BOTLEY WEST SOLAR FARM
OXFORDSHIRE HOST AUTHORITIES
RESPONSES FOR
DEADLINE 6 | MONDAY 20 OCTOBER 2025

Botley West Solar Farm (EN01014)

RESPONSES FOR DEADLINE 6

**rpsgroup.com**  
101 Park Drive, Milton Park, Abingdon, Oxfordshire, OX14 4SH  
T: +44(0)1235 821 888 E: rps.ox@tetratech.com

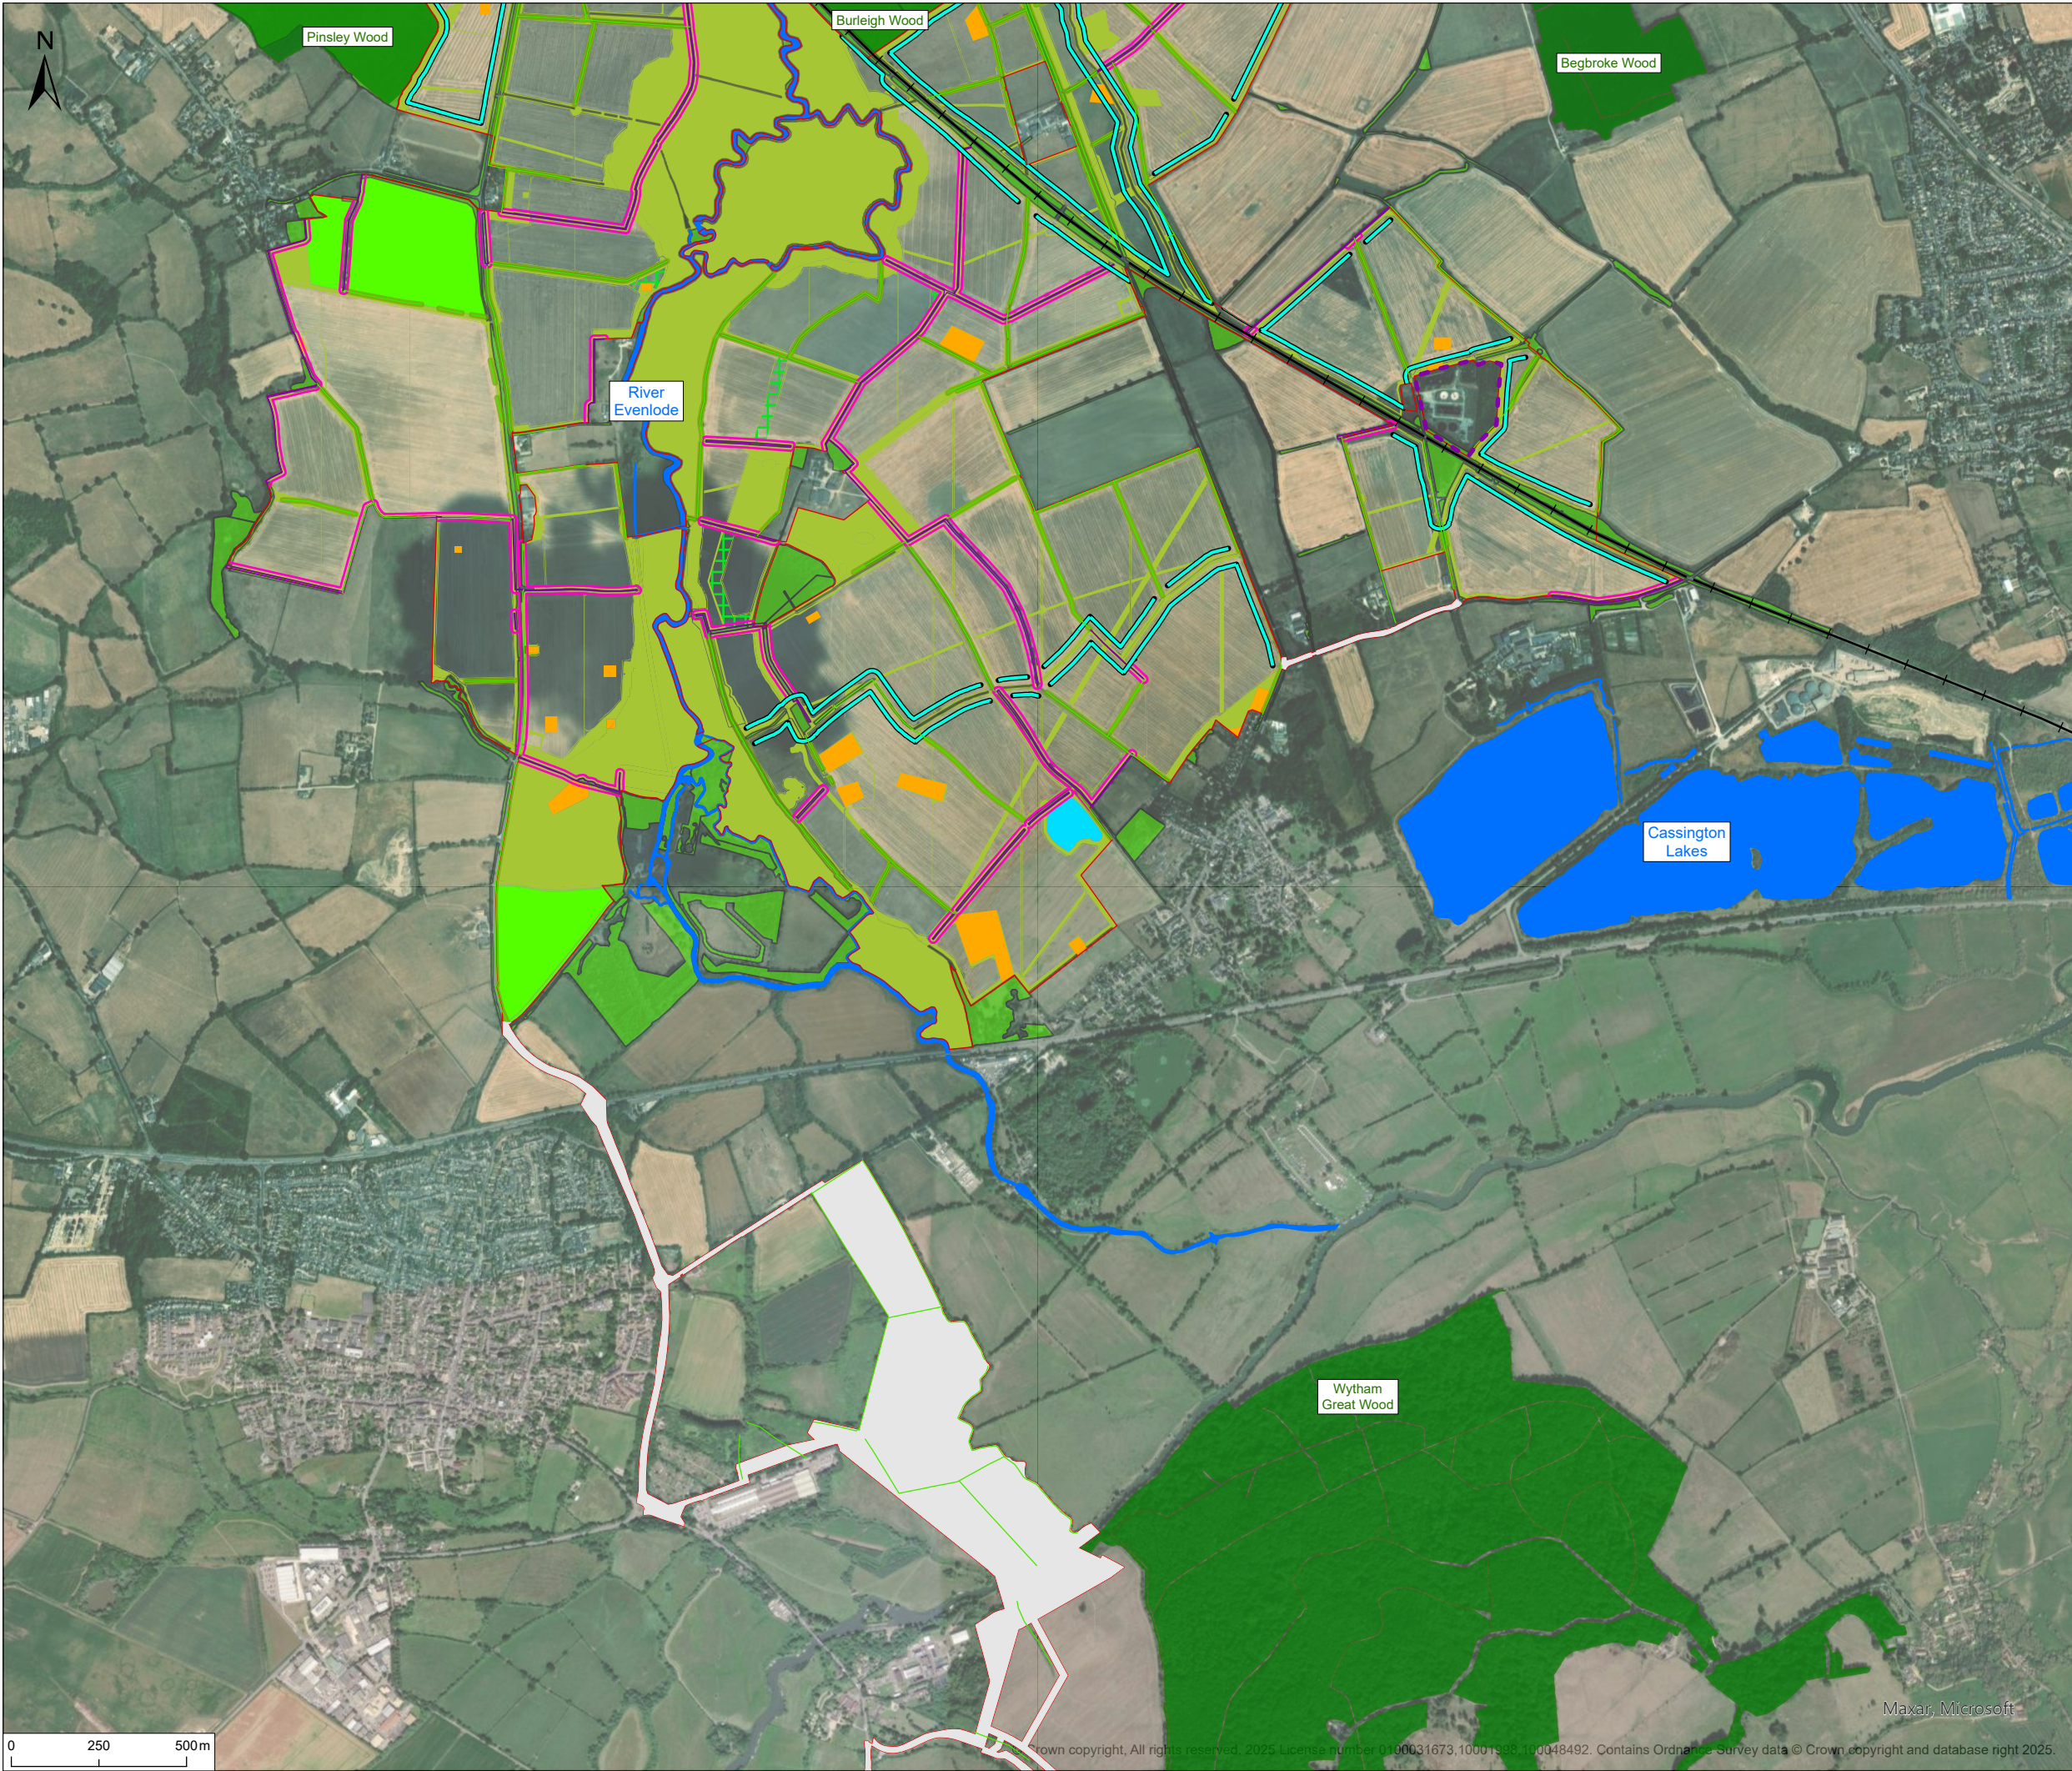
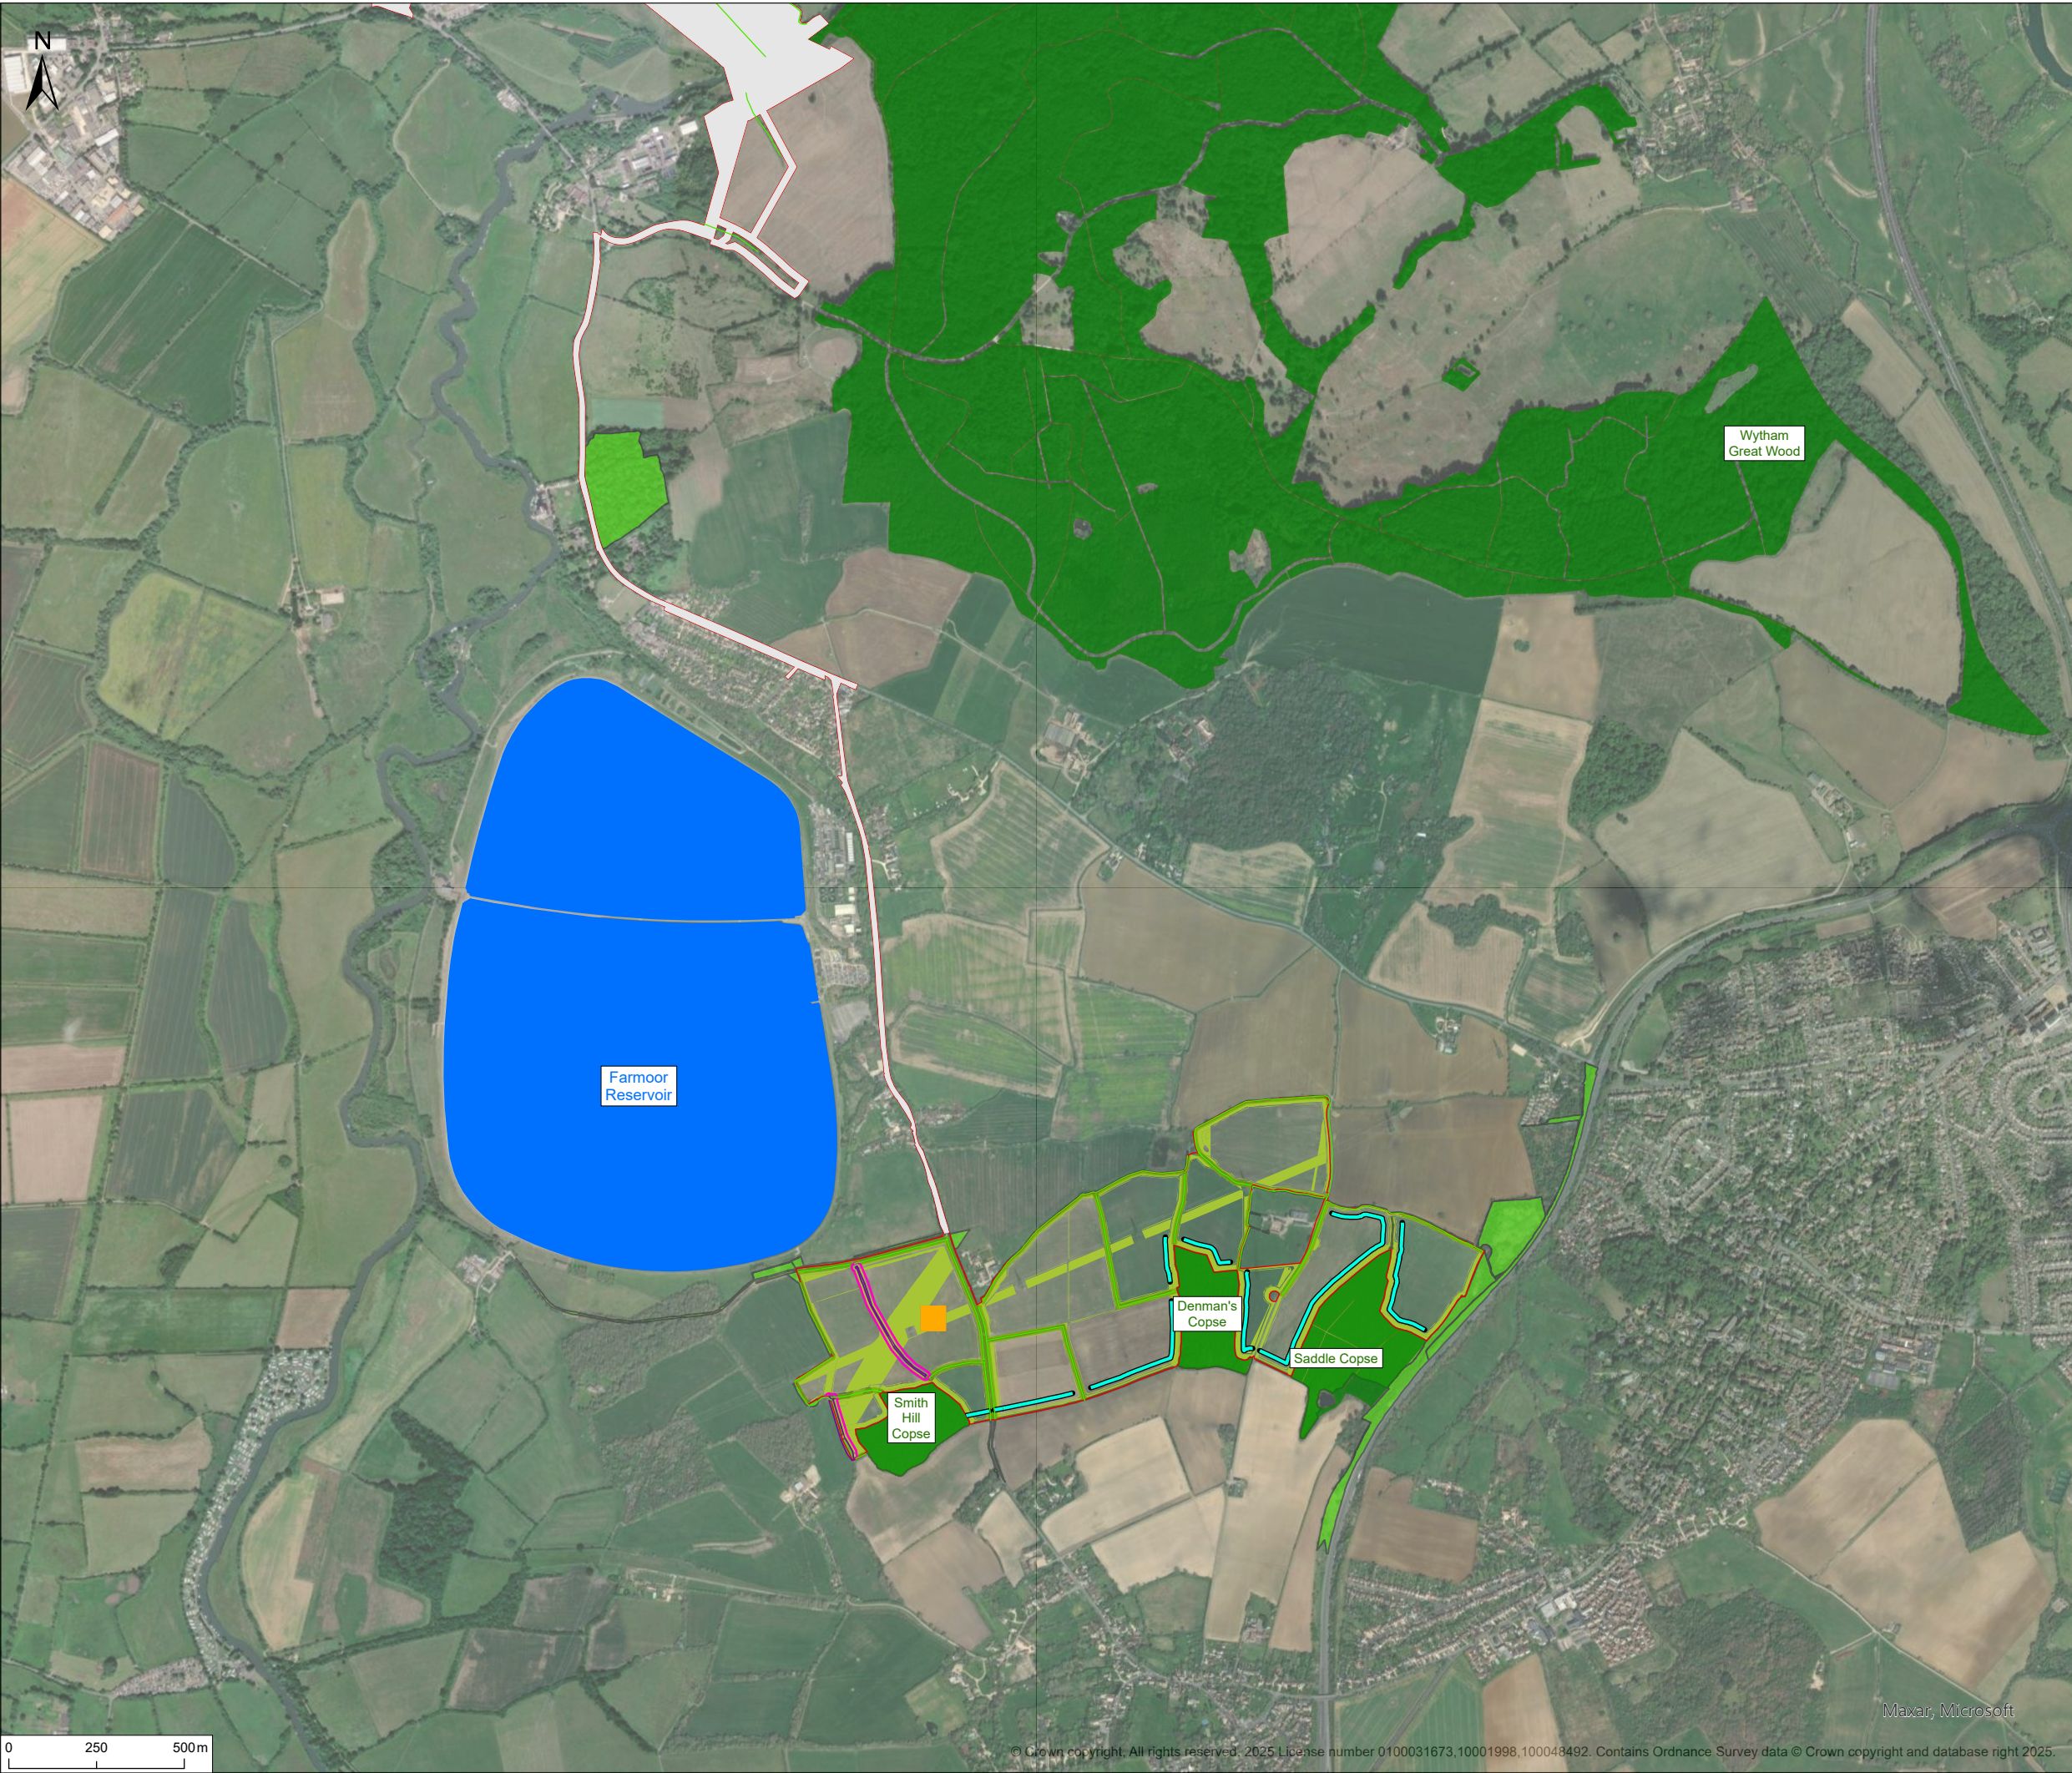
The proposal for a 3-tiered system of buffers alongside hedgerows and woodlands is welcomed, and we agree that the specifications and locations for all Tier A buffers must be confirmed before approval. We request that the locations of all Tier A flight paths must be clearly identified on a set of plans for clarity and agreement and adopted as part of the DCO. Although a list is described in Section 8.5.2 of the oLEMP and Section 8.5.3 states that *“given the importance of the Tier A buffers to the bat ecology within the landscape, the location of these will be fixed at this stage to ensure their location is secured by virtue of their inclusion within this oLEMP”*, we cannot currently see these on a map of the site and no specification is provided for the length or area. Further details therefore must be provided.
